## NSW RURAL FIRE SERVICE

Your reference: SSD-17647189  
Our reference: DA20210424001613-EIS & DA  
Exhibition-1

**State Significant Development - Warehouse or Distribution Centre  
Request for comments - exhibited Environmental Impact Statement (EIS)  
SSD-17647189 884-928 Mamre Road Kempers Creek NSW 2178, 52//DP259135**

11213_DA011

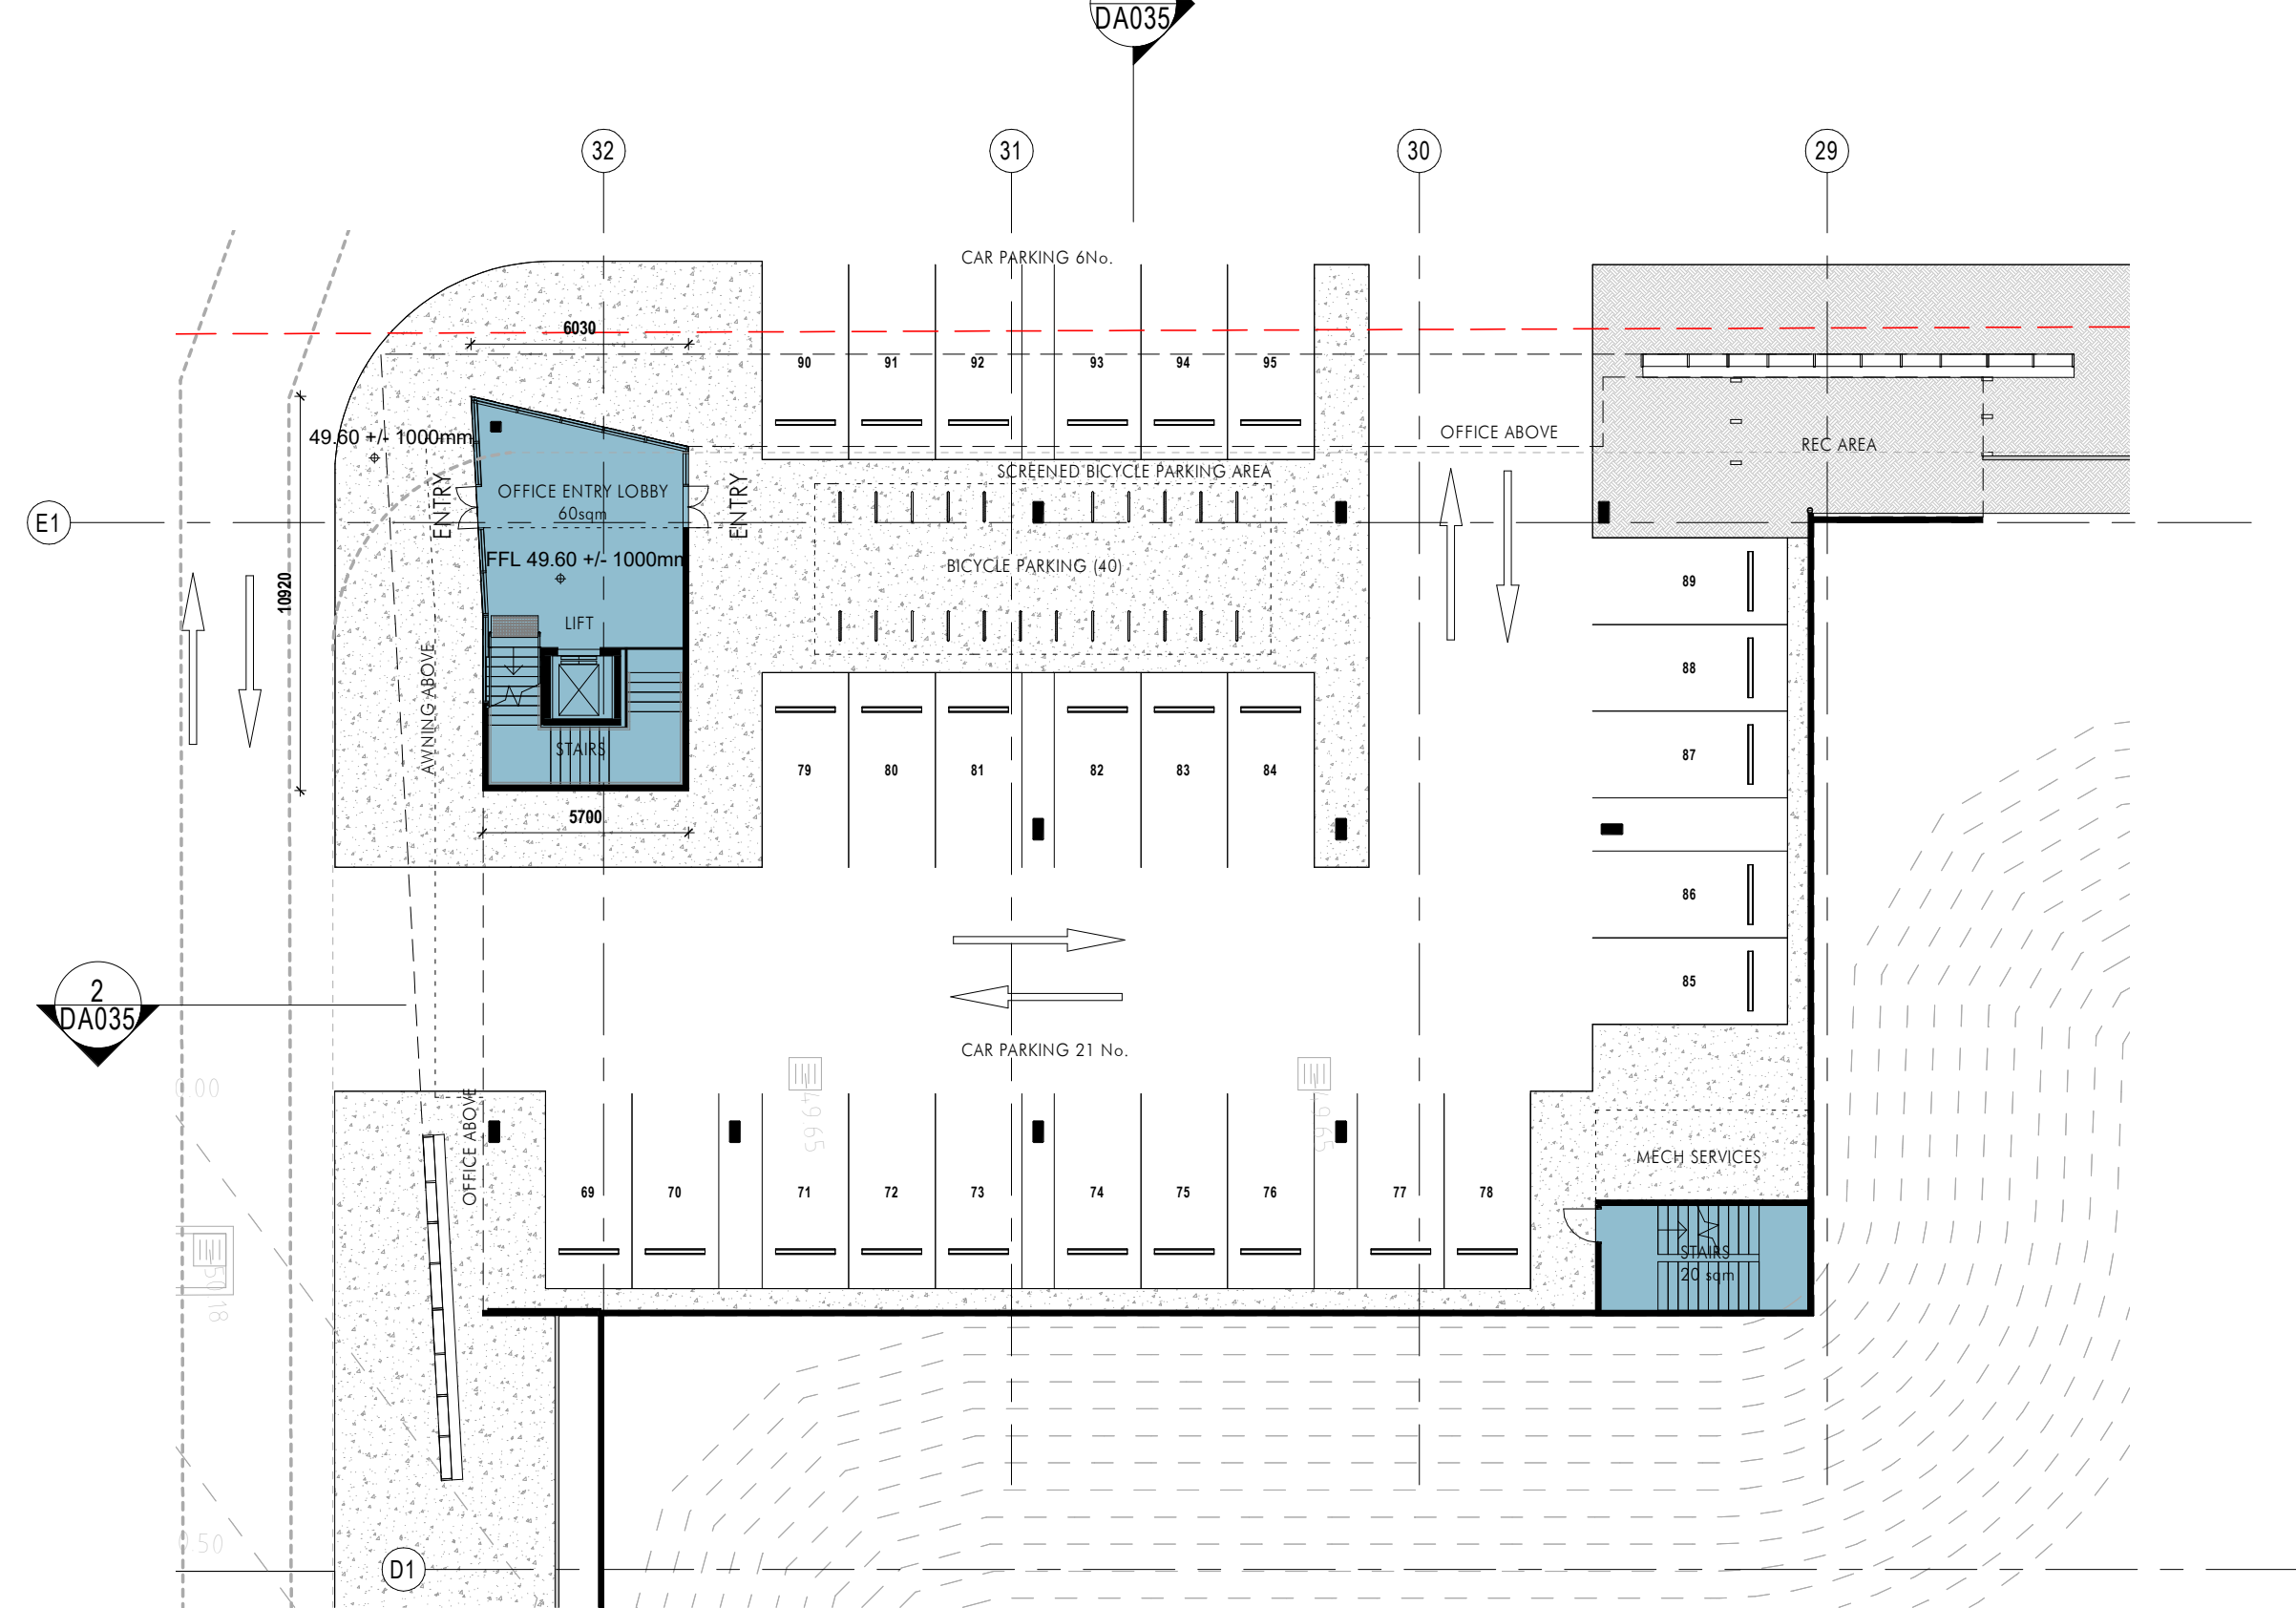
1. All lots (except for Lot 3 road dedication and the bio-retention basin/s) must be managed in perpetuity as an inner protection area (IPA) in accordance with the requirements of Appendix 4 of *Planning for Bush Fire Protection 2019*. When establishing and maintaining an IPA, the following requirements apply:

- Tree canopy cover be less than 15% at maturity;
- Trees at maturity are not touching or overhang the building;
- Lower limbs are removed up to a height of 2m above the ground;
- Tree canopies are separated by 2 to 5m;
- Preference is given to smooth-barked and evergreen trees;
- Large discontinuities or gaps in vegetation are provided to slow down or break the progress of fire towards buildings;
- Shrubs are not located under trees;
- Shrubs do not form more than 10% of ground cover;
- Clumps of shrubs are separated from exposed windows and doors by a distance of at least twice the height of the vegetation.
- Grass to be kept mown (as a guide grass should be kept to no more than 100mm in height);
- Leaves and vegetation debris are removed; and
- NSW Rural Fire Service's document *Standards for asset protection zones*.

Drawing Title:
Overall Landscape Plan
 DWG No:
LDA-01

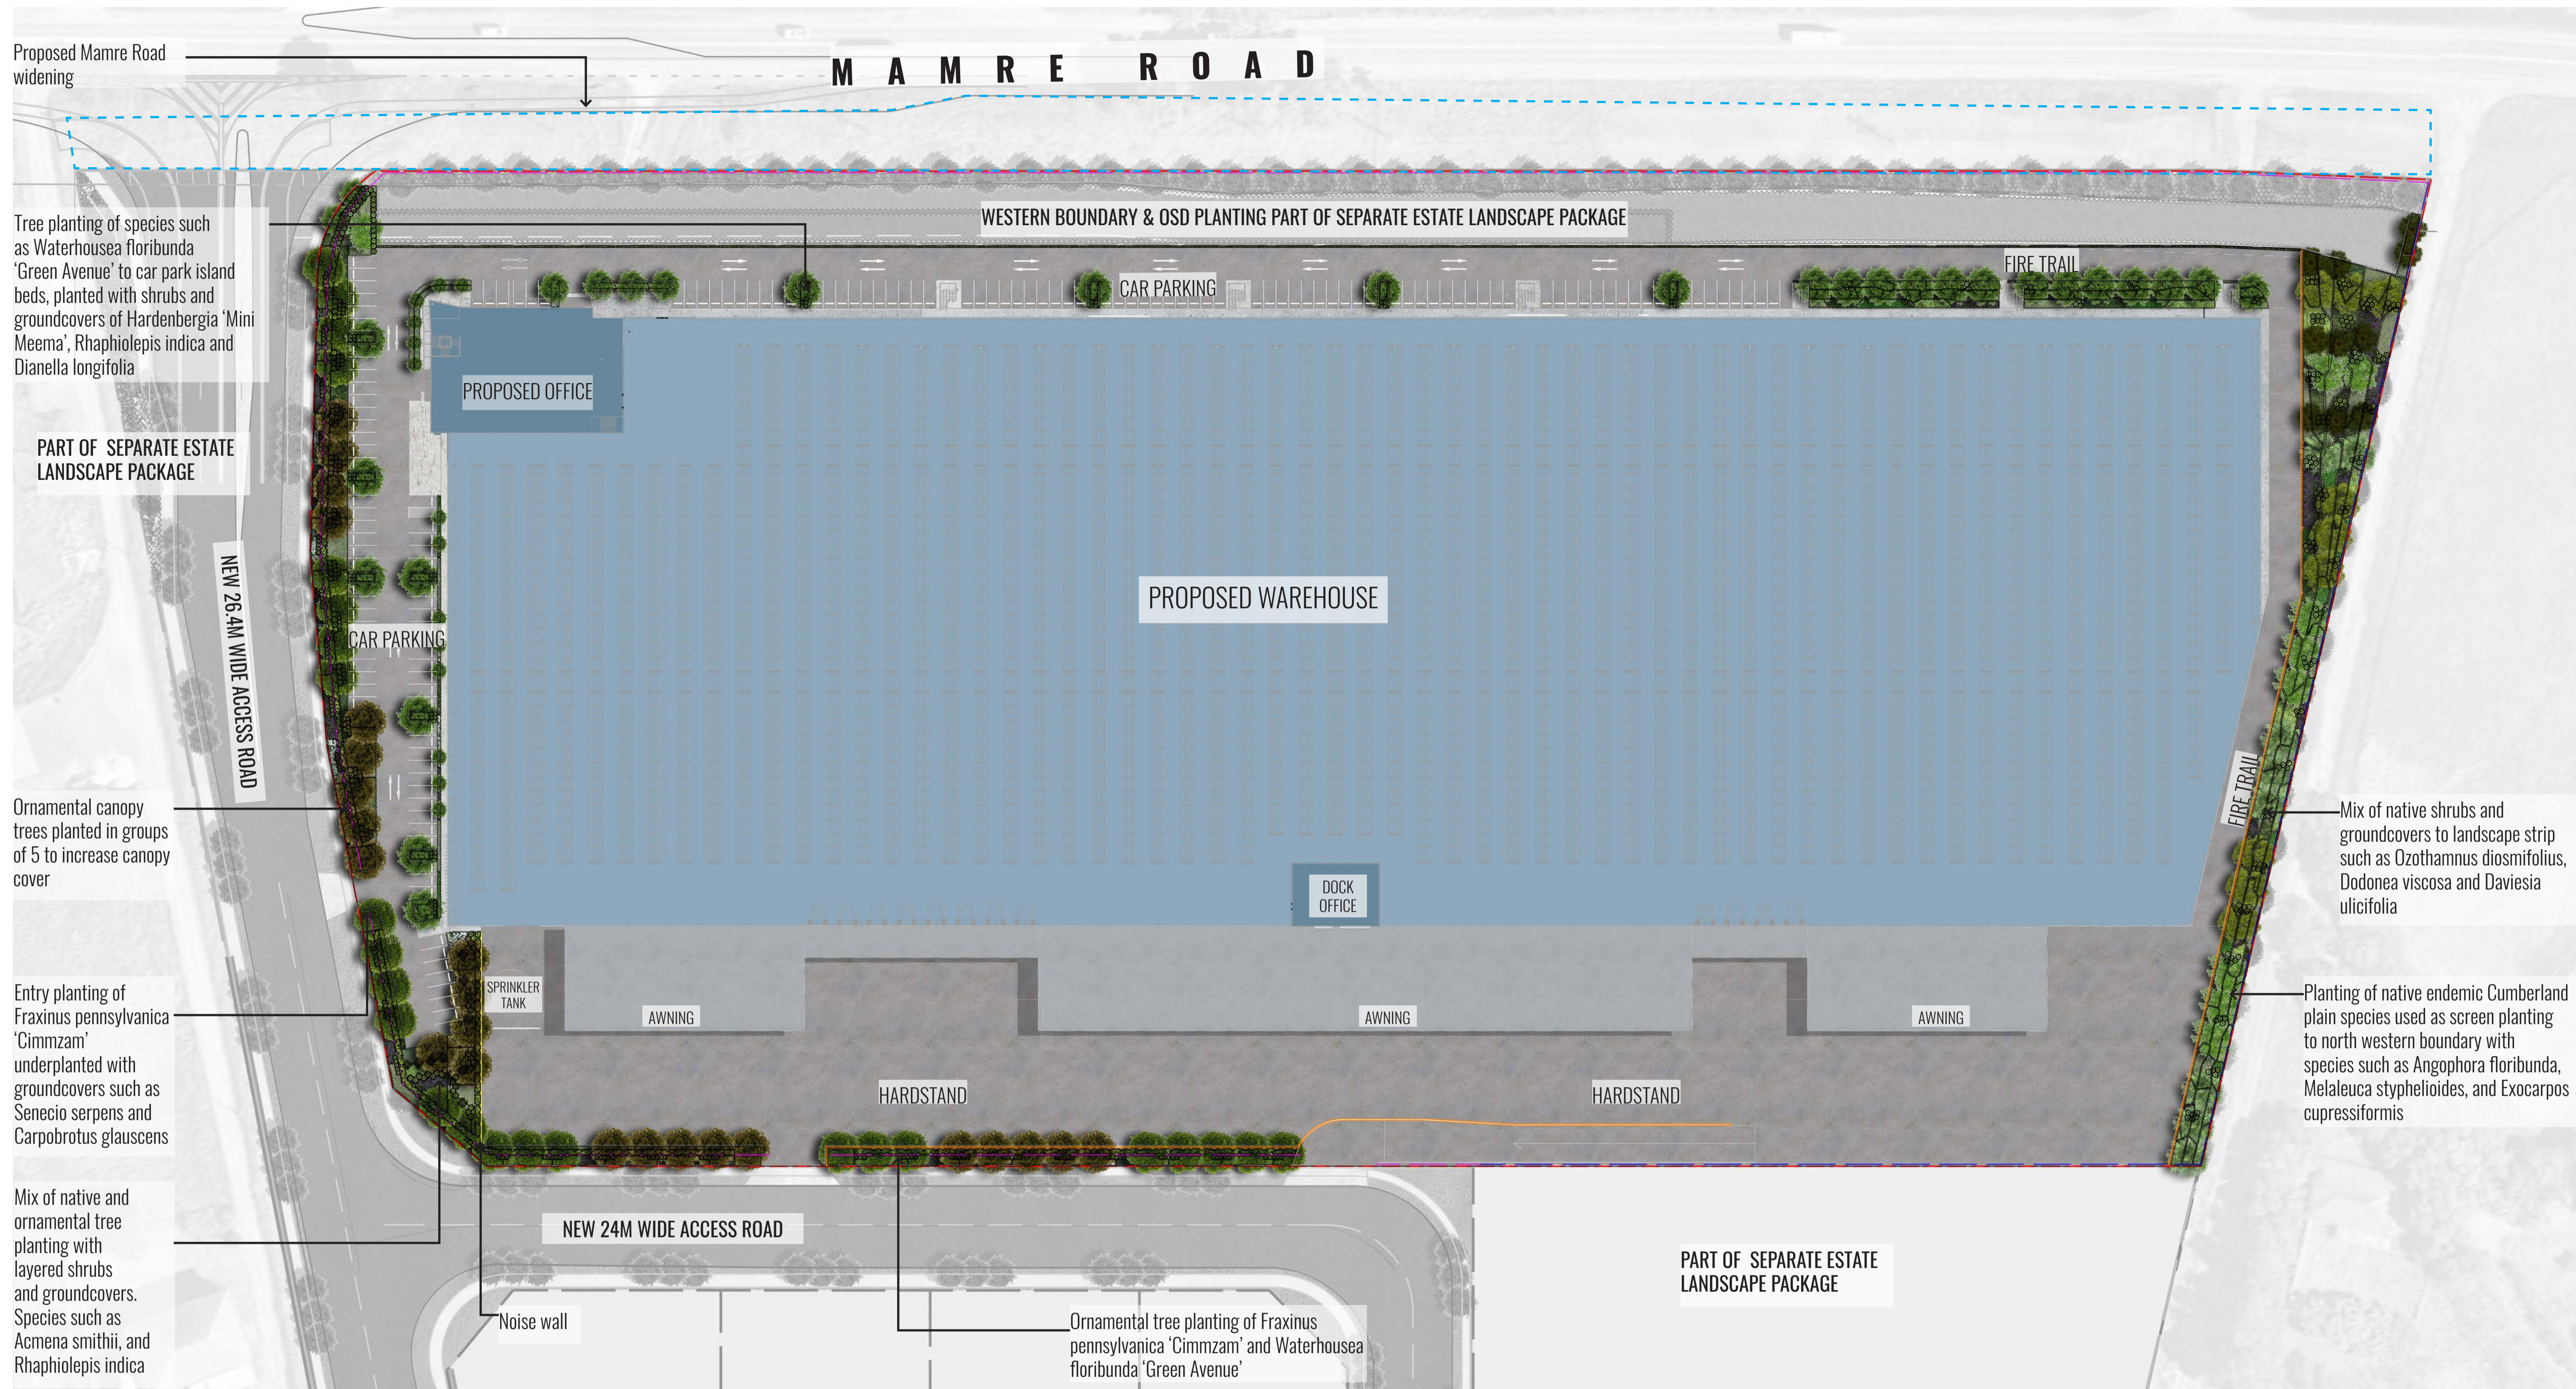
2. Landscaping within the inner protection area (IPA) must comply with Appendix 4 of *Planning for Bush Fire Protection 2019*. In this regard, the following principles are to be incorporated:

- A minimum 1 metre wide area (or to the property boundary where the setbacks are less than 1 metre), suitable for pedestrian traffic, must be provided around the immediate curtilage of the building;

- Planting is limited in the immediate vicinity of the building;
- Planting does not provide a continuous canopy to the building (i.e. trees or shrubs are isolated or located in small clusters);

- Landscape species are chosen to ensure tree canopy cover is less than 15% (IPA) at maturity and trees do no touch or overhang buildings;
- Avoid species with rough fibrous bark, or which retain/shed bark in long strips or retain dead material in their canopies;

- Use smooth bark species of trees species which generally do not spread fire up the bark into the crown;
- Avoid planting of deciduous species that may increase fuel at surface/ ground level (i.e. leaf litter);

- Avoid climbing species to walls and pergolas;
- Locate combustible materials such as woodchips/mulch, flammable fuel stores away from the building;
- Locate combustible structures such as garden sheds, pergolas and materials such as timber garden furniture away from the building; and

- Low flammability vegetation species are used.
